SUBJECT: SE-22-00014 Tapert

#### **Public Works Access and Engineering SEPA Application Comments**

**ARCHITECTURAL SITE PLAN**

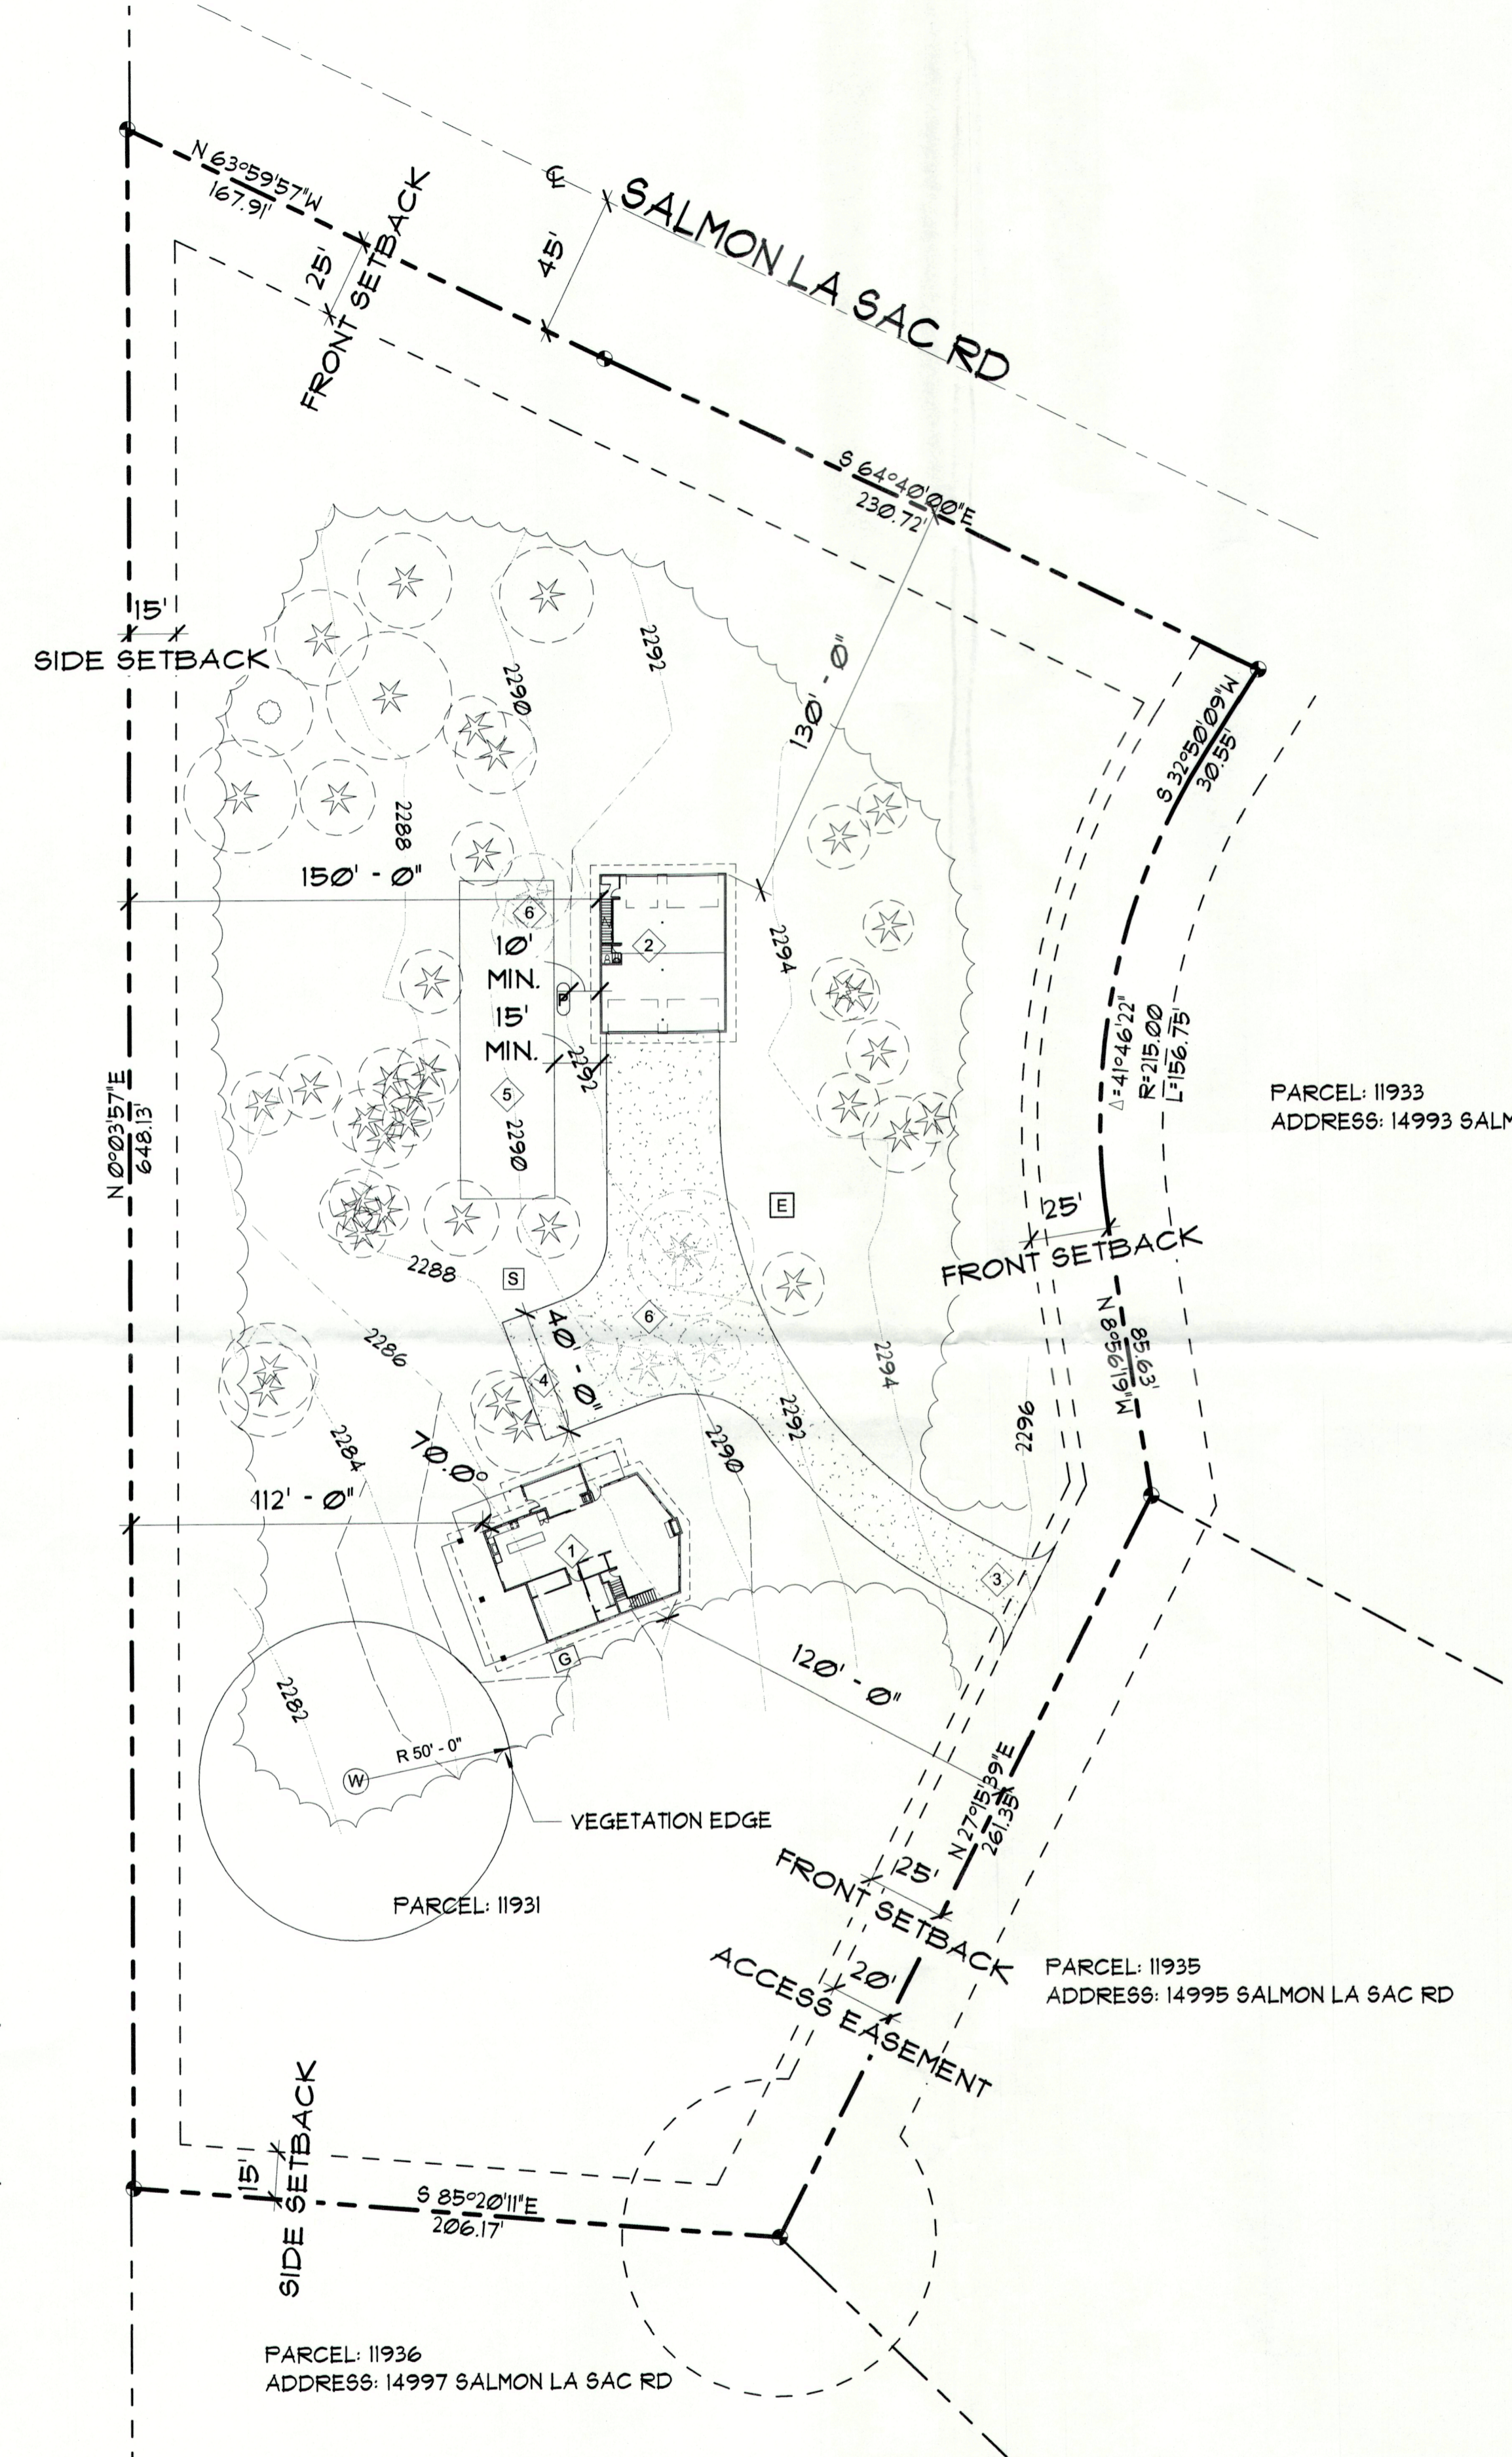
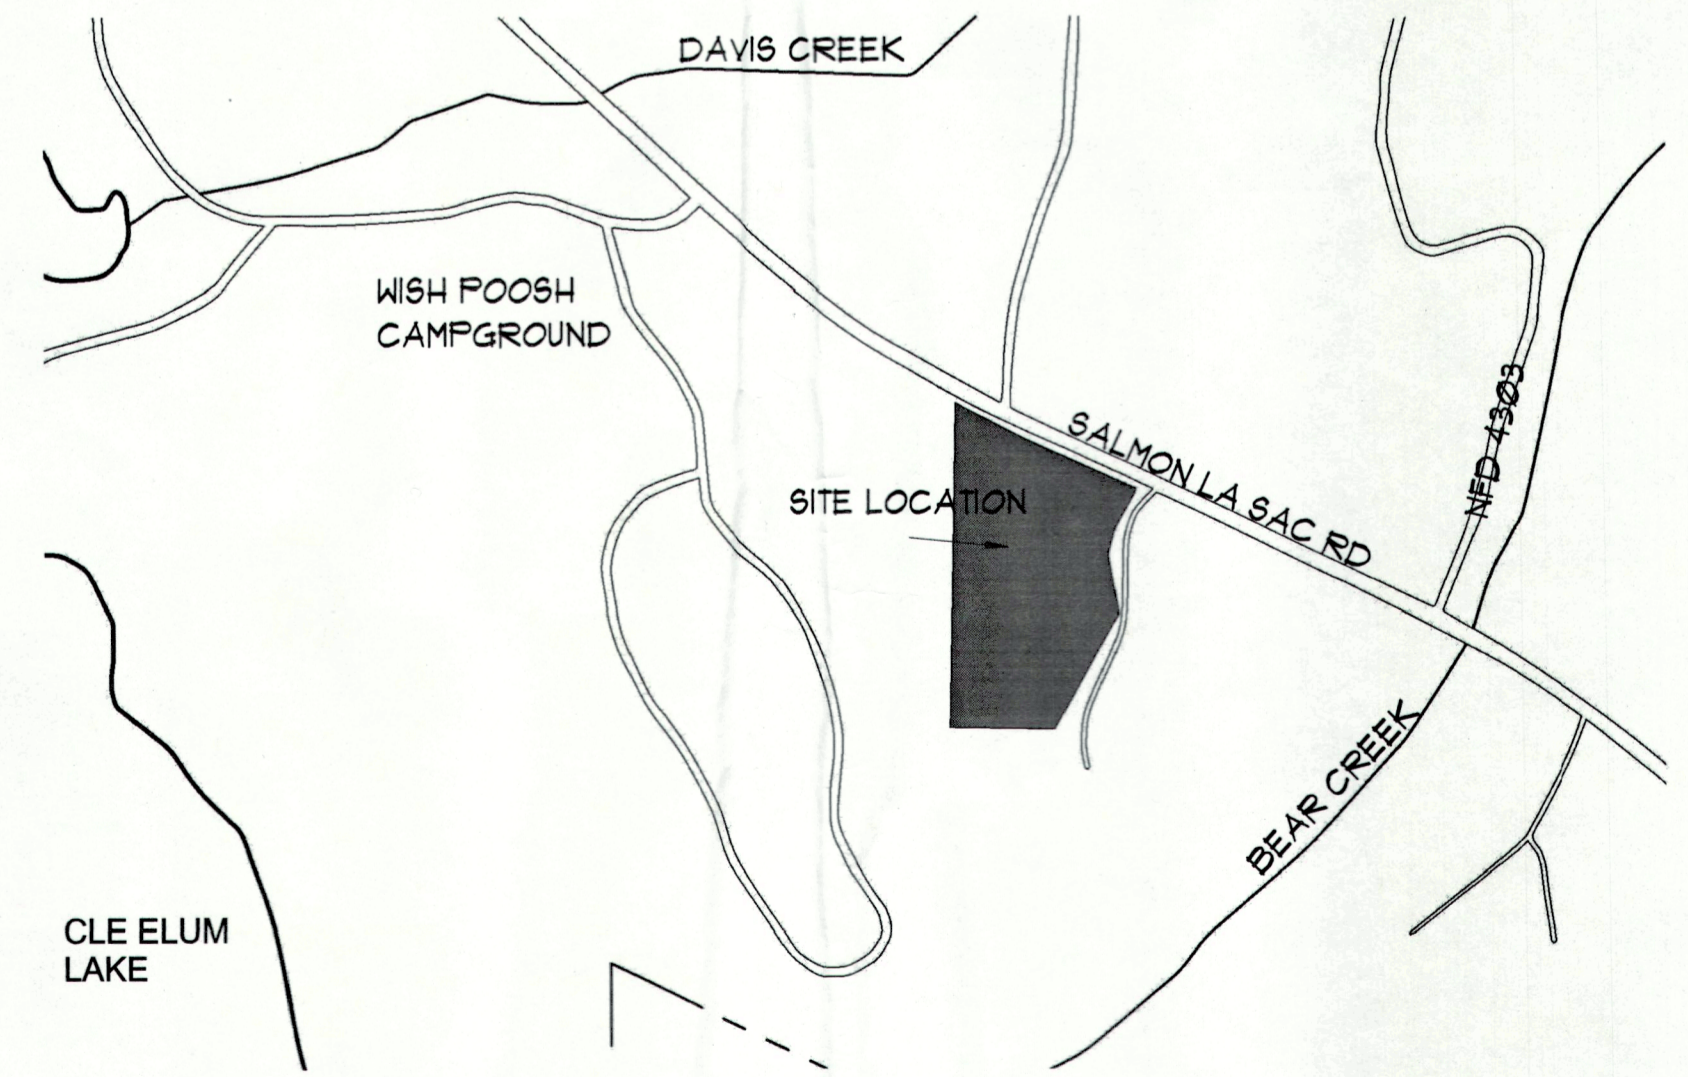
I don't have any comments on the Building side of the project but I did notice on the site plan that a separate guest house/ guest dwelling is noted under the Project Data and Site Plan Keynote #2. I checked on Compas and this parcel appears to be in a Rural Recreation zone with a 5 acre minimum lot size. Since the lot is only 4 acres I don't believe a separate dwelling (or ADU) would be allowed. I must defer to Planning on this interpretation but thought it should be noted prior to a preliminary site analysis completed.
